GRANT HAYS ASSOCIATES

DATE: May 17, 2016
TO: Jennifer Bartlett – Maine State Fire Marshal Office
FROM: Mike Hays
RE: Foundation Brewery Expansion
Permit Review Comments
CC: file

Attached are the revisions to the Permit drawings which address your comments dated 4/22/16. All the revisions are Rev-Clouded with a Delta 1 designation. Please let me know if you have any additional questions.

SHEET  
A2

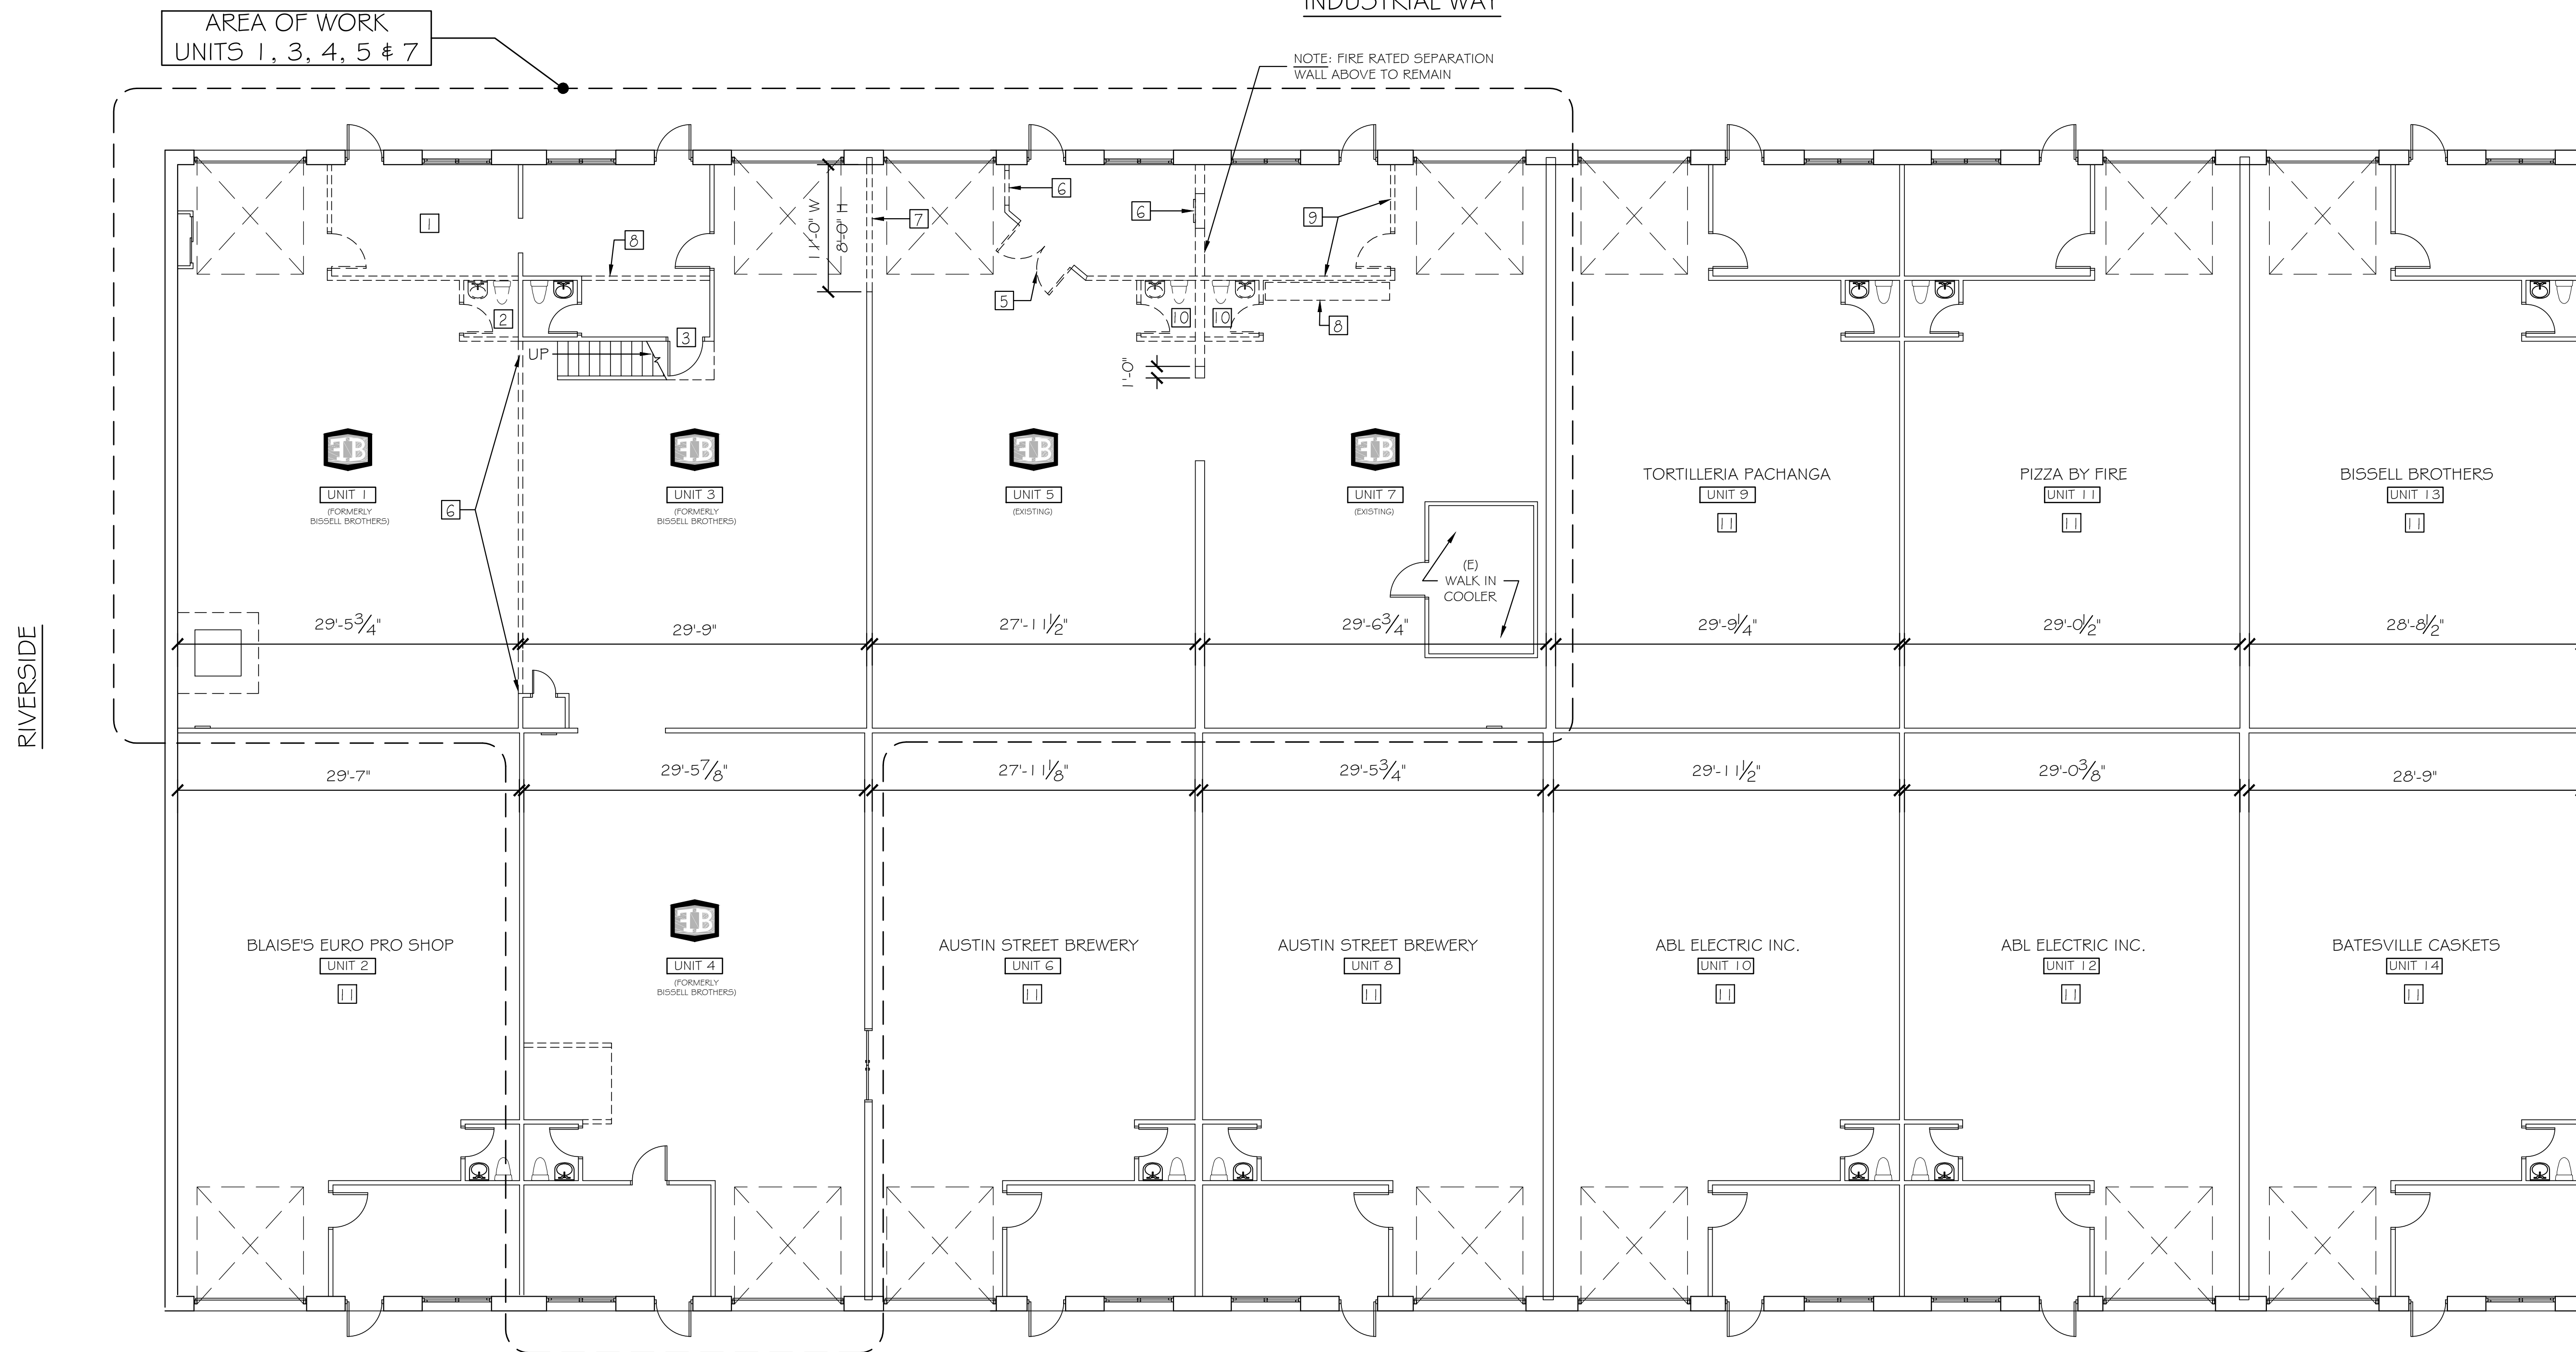
1. Deleted Demolition Note #5 for existing pair of doors between Tasting Room 102 & Production. These shall remain in the smoke partition (non-fire rated).
2. Identified location of existing boiler in Production (Unit #5).

SHEET  
**A4**  
COPYRIGHT  
REPRODUCTION OR RELIANCE OF THIS  
DOCUMENT WITHOUT WRITTEN  
PERMISSION FROM GRANT HAYS  
ASSOCIATES IS PROHIBITED.

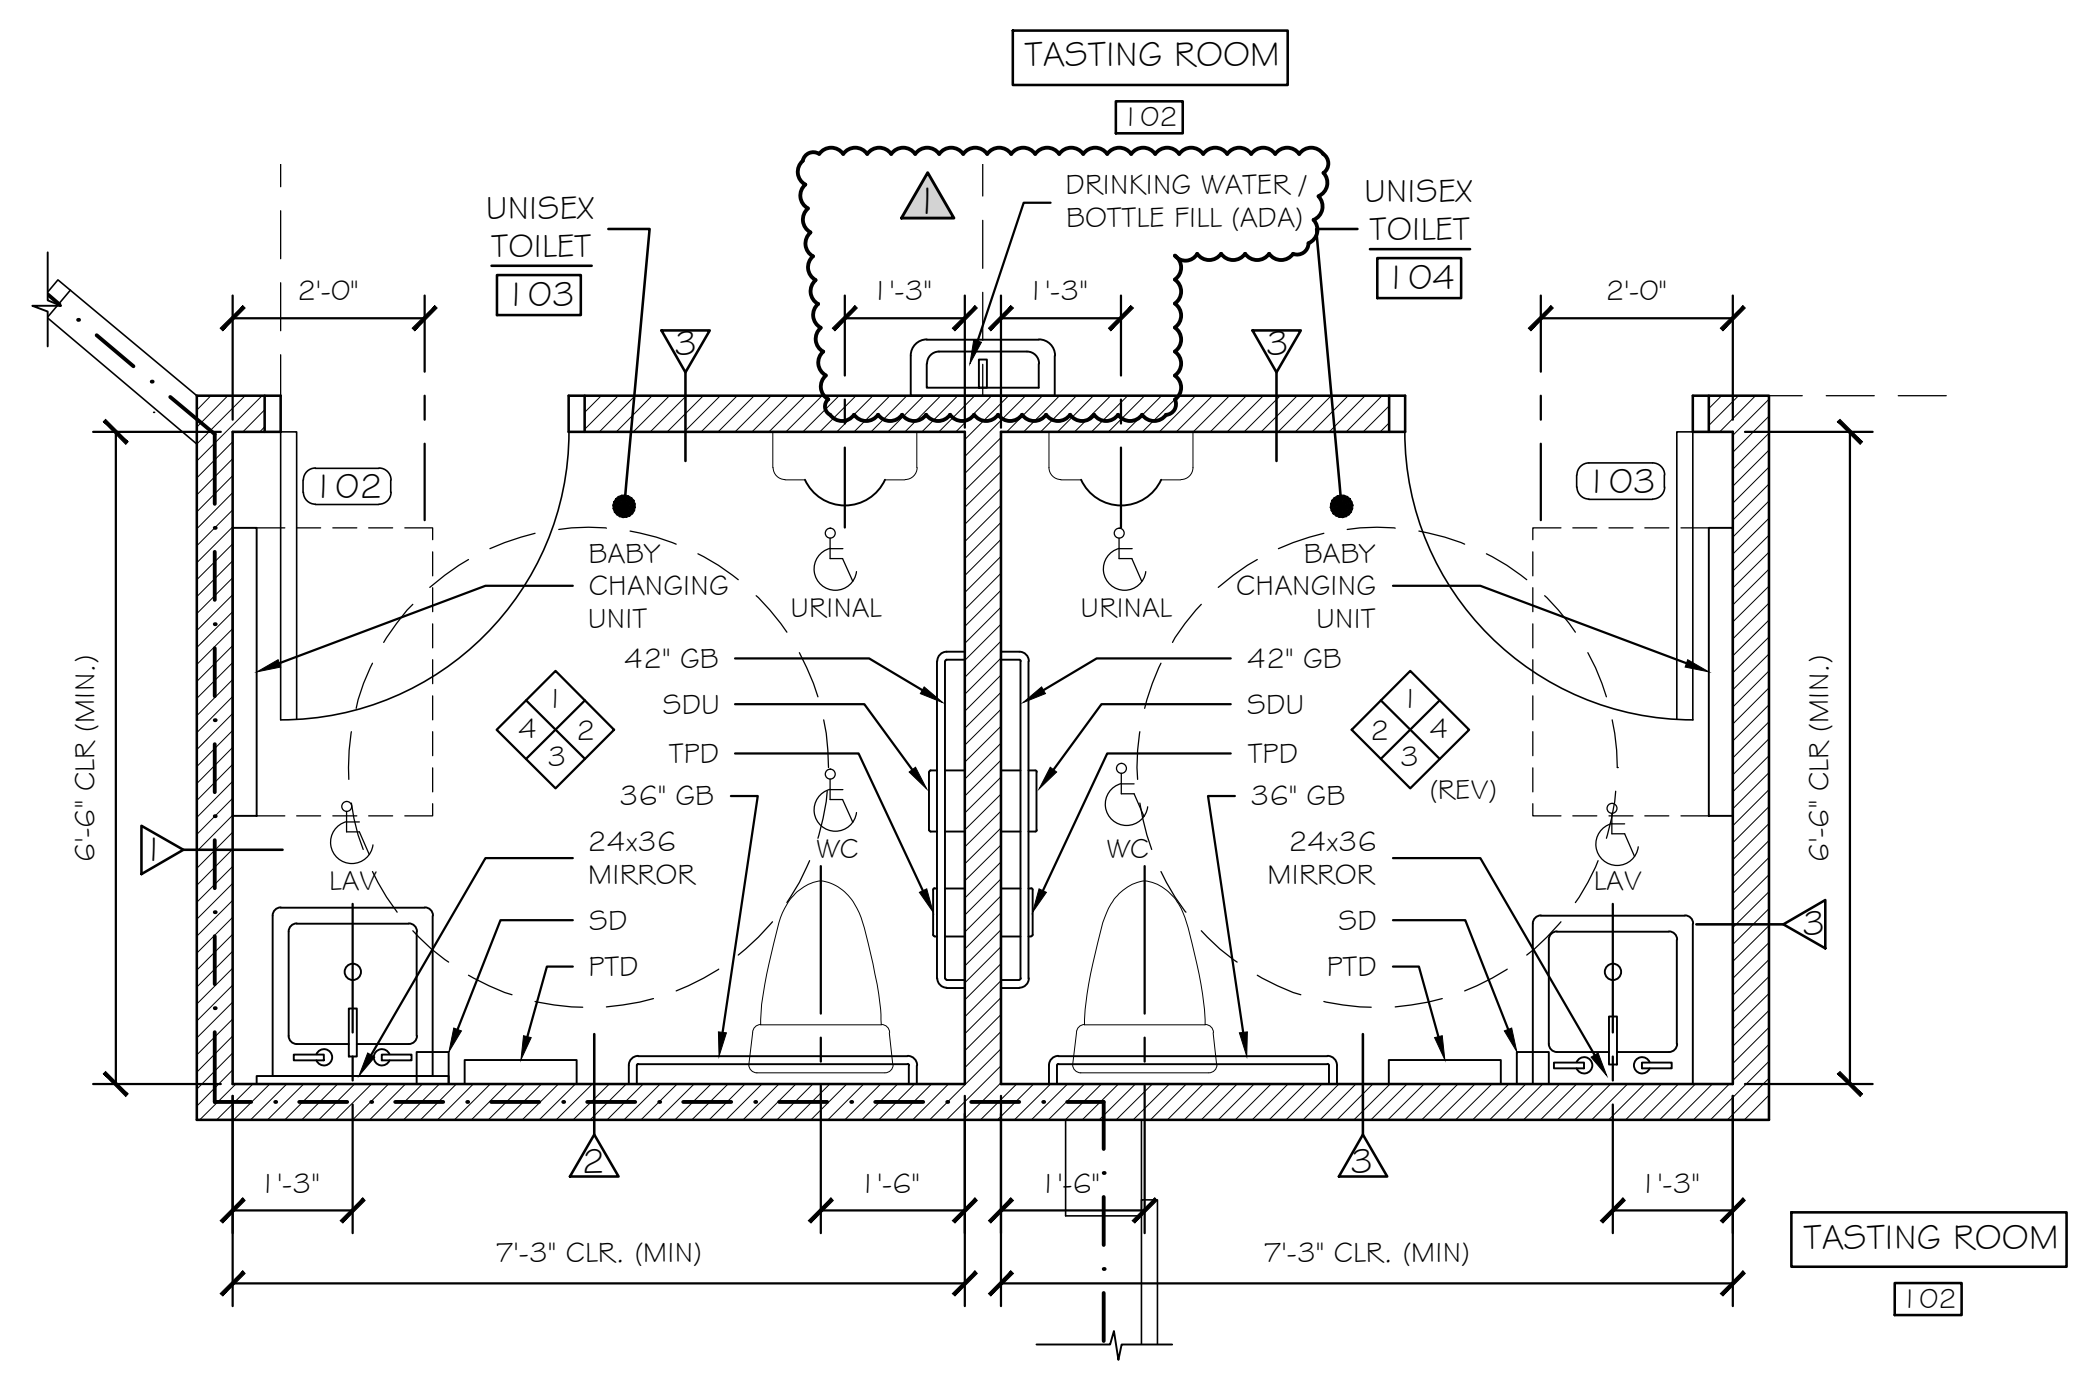
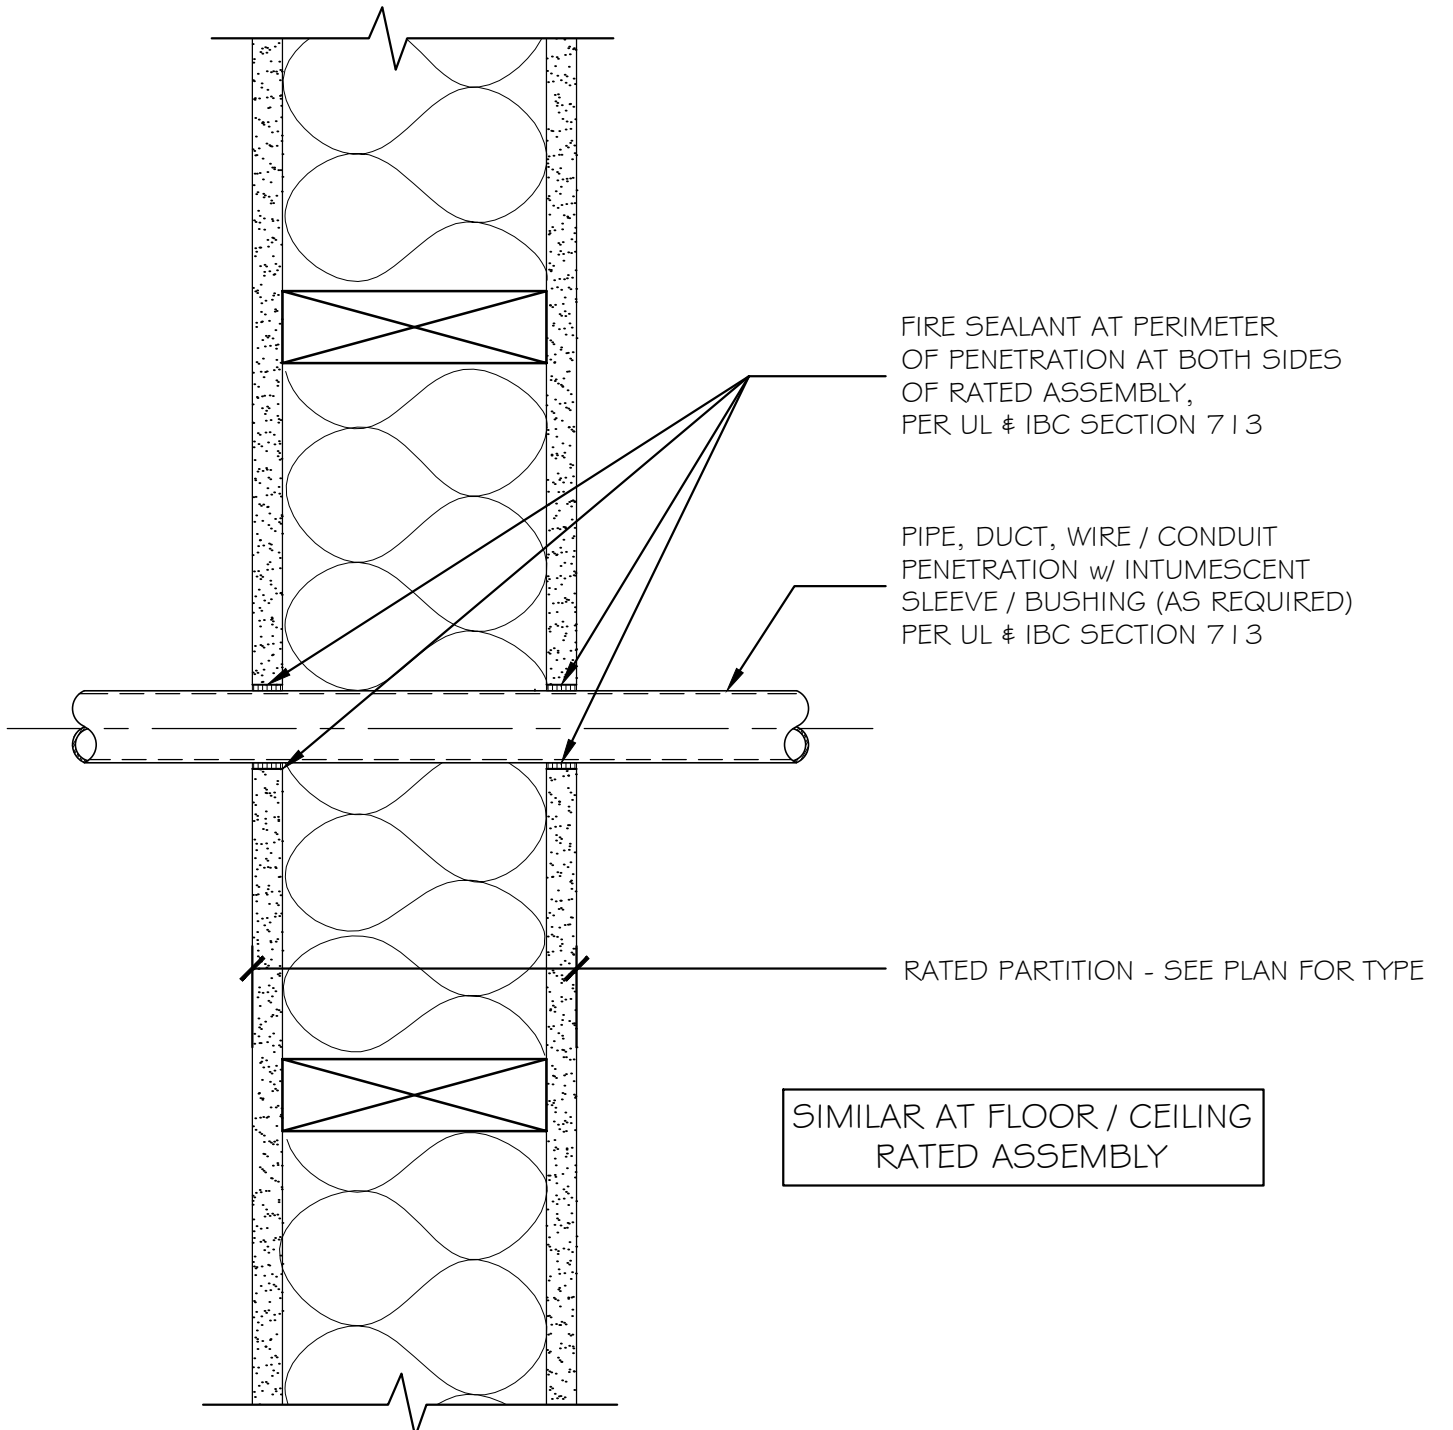
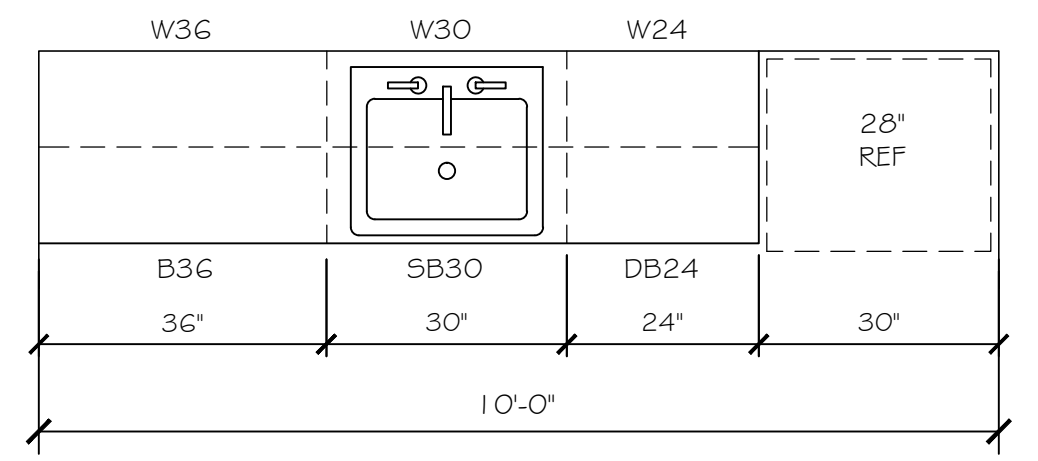
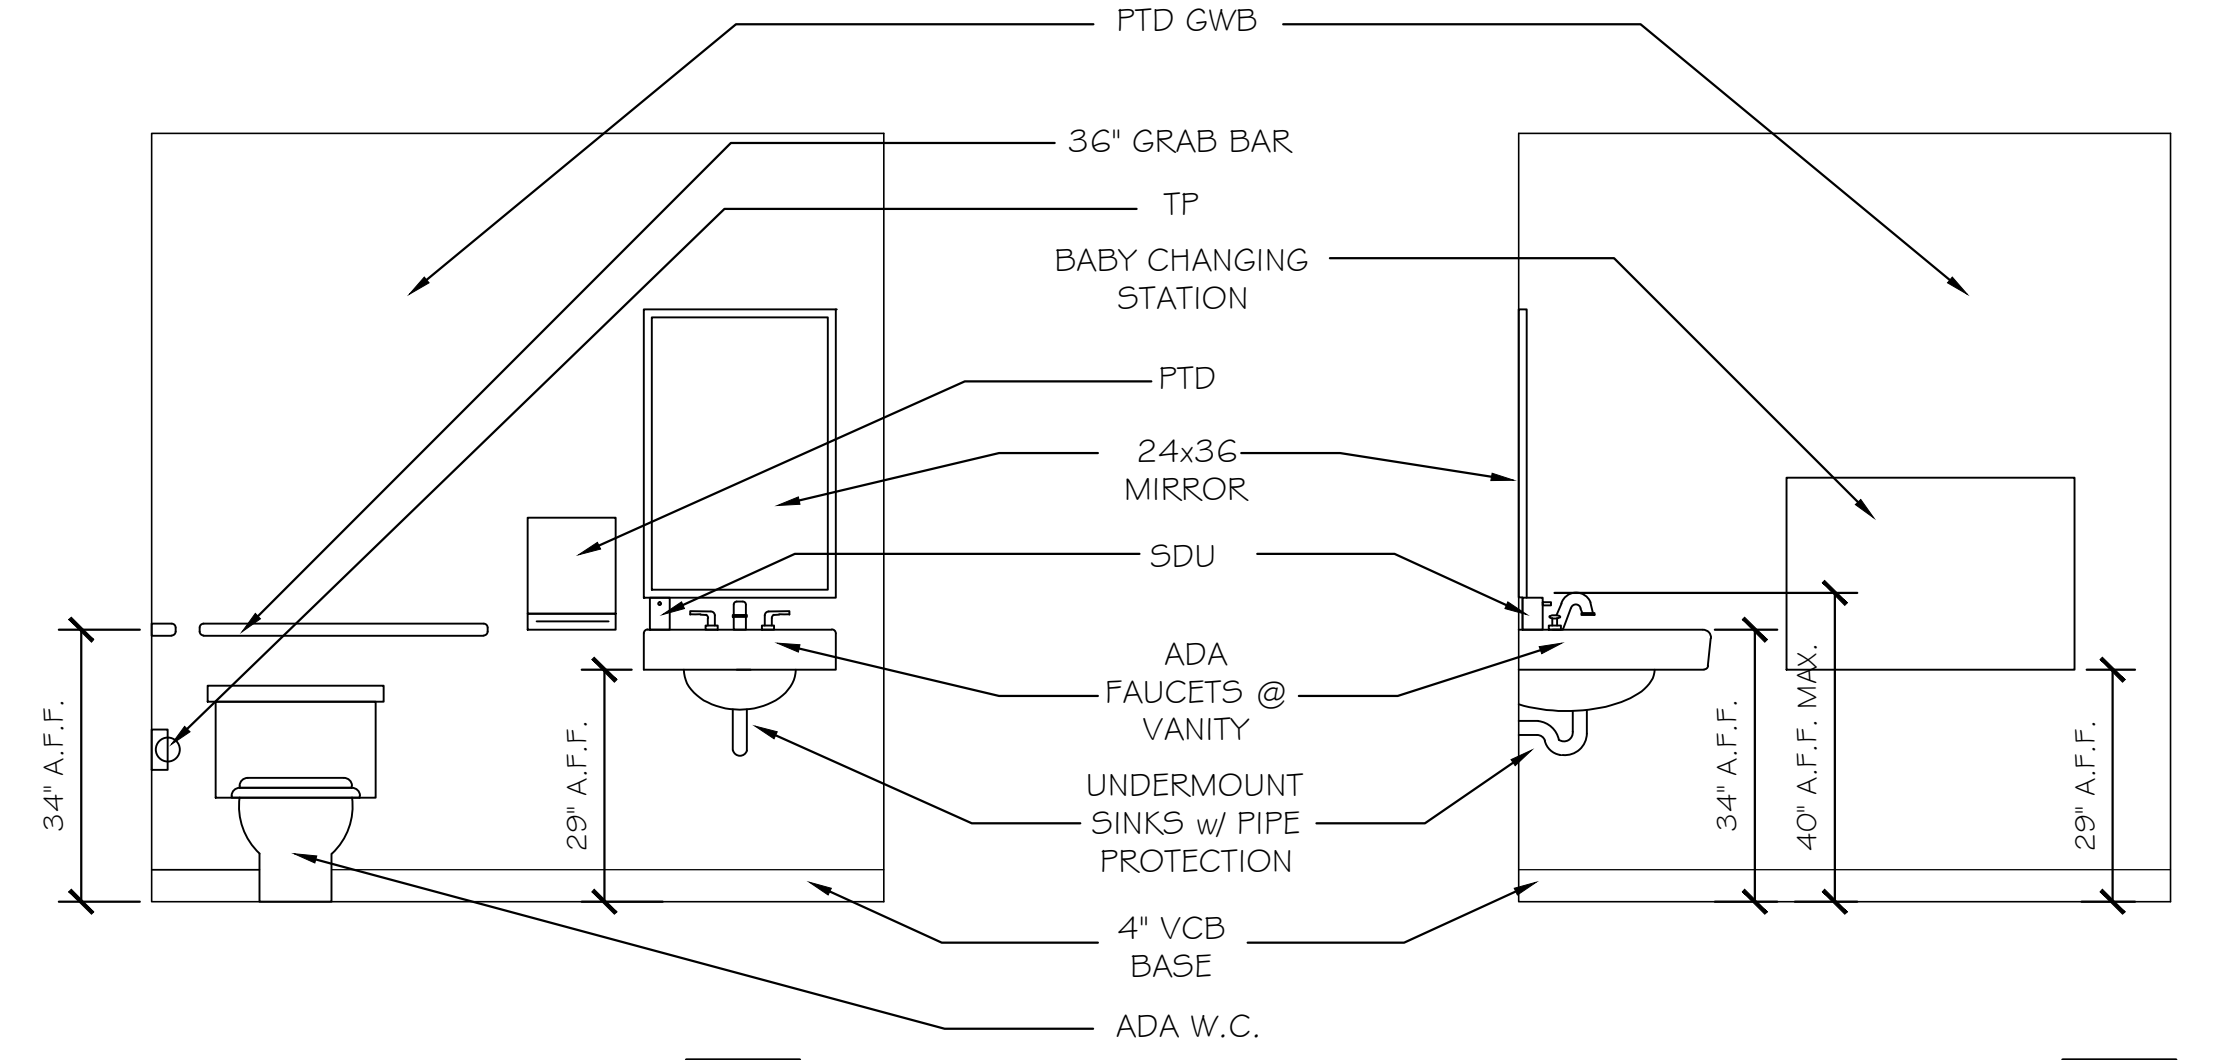
1. Detail 2 – Modified Partition Legend for smoke separation wall, added dimensions for sink and mirror, referred builders to ADA Sheet A6 for dimensional criteria. Added water bottle fill station at seating area outside bathroom wall.
2. Modified Detail 3 for firestopping note.
3. Added Detail 4 for screen wall between merchandise storage area and seating area at Tasting Room 102.
